From: Neil Whitton
Sent: 22 April 2022 15:51
To: Rebekah Morgan
Cc: DC Support <DC.Support@cherwell-dc.gov.uk>
Subject: RE: 22/00907/REM - Land Adj To Promised Land Farm, Wendlebury Road, Chesterton, Oxfordshire

From: Neil Whitton
Sent: 22 April 2022 15:50
To: Rebekah Morgan
Cc: DC Support
Subject: 22/00907/REM - Land Adj To Promised Land Farm, Wendlebury Road, Chesterton, Oxfordshire

**RM2 APPLICATION External Works & Levels**

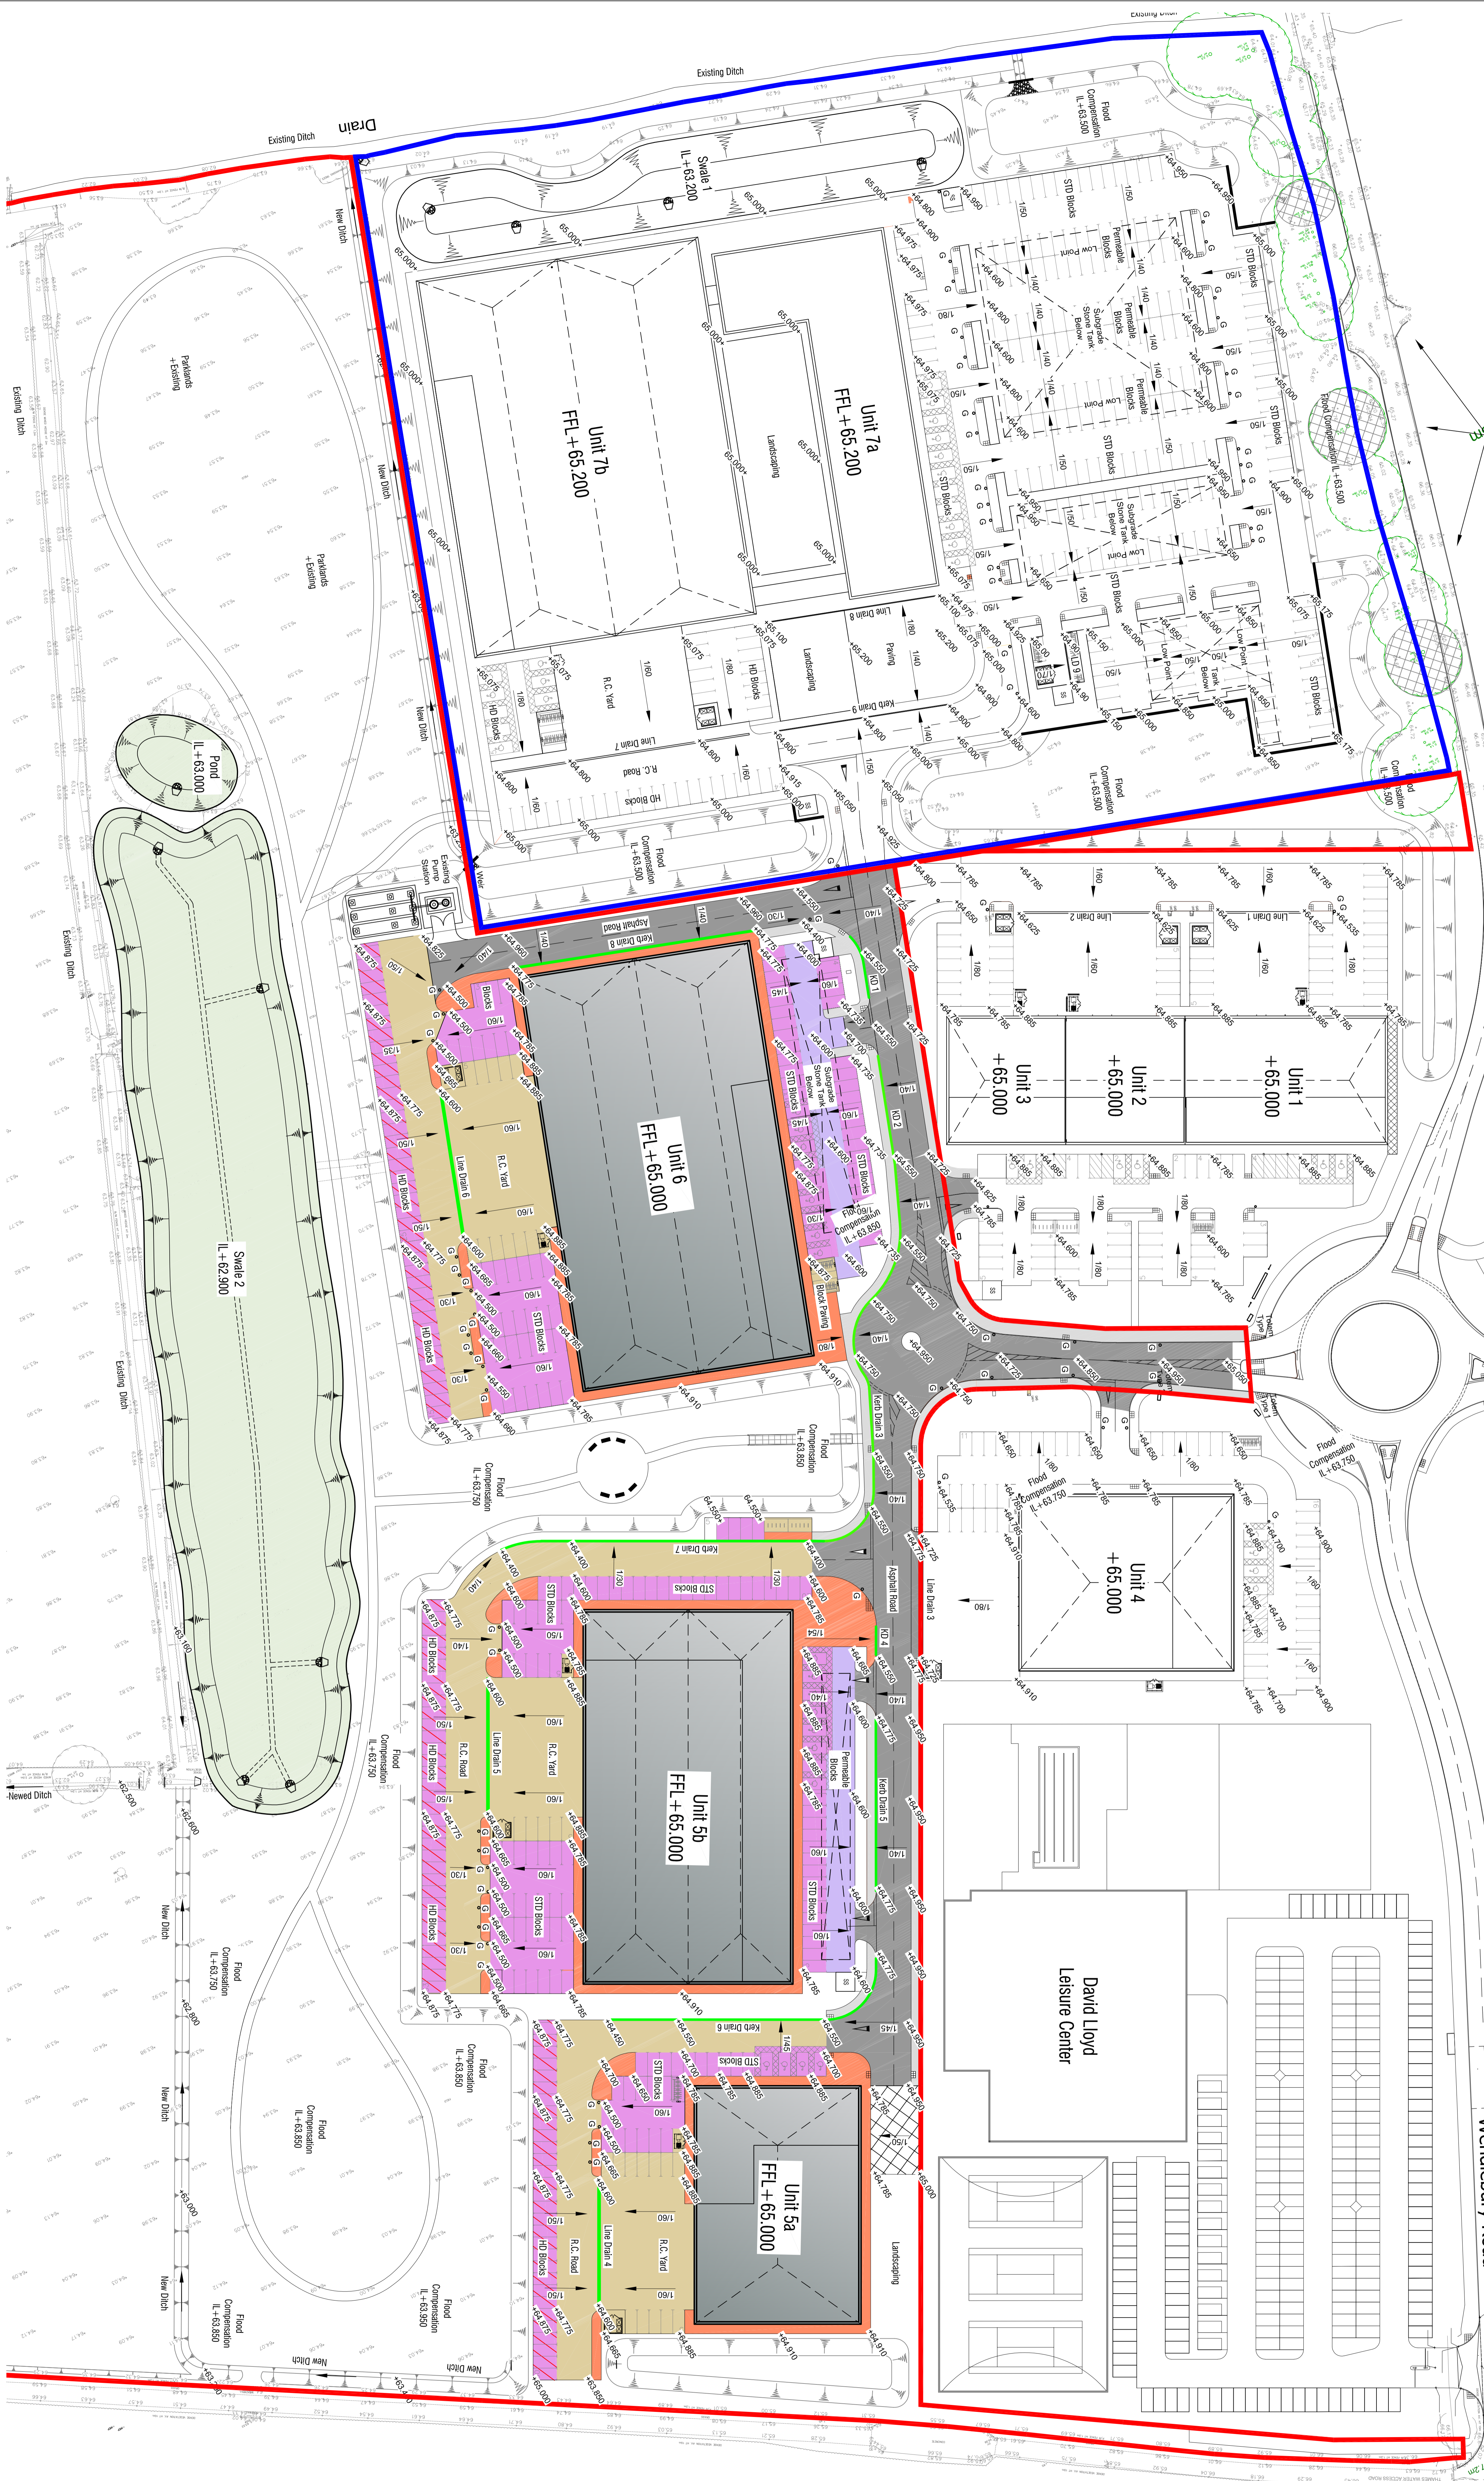
Sorry, I note that it is 32 EV charge pints for this application.

My only comment on this application is that whilst I am pleased to see 14 EV charge points included in the application I would have hoped to see provision made for ducting to the remaining parking spaces to allow for the easy expansion of the EV charging network – especially given the proposed occupants of the building.
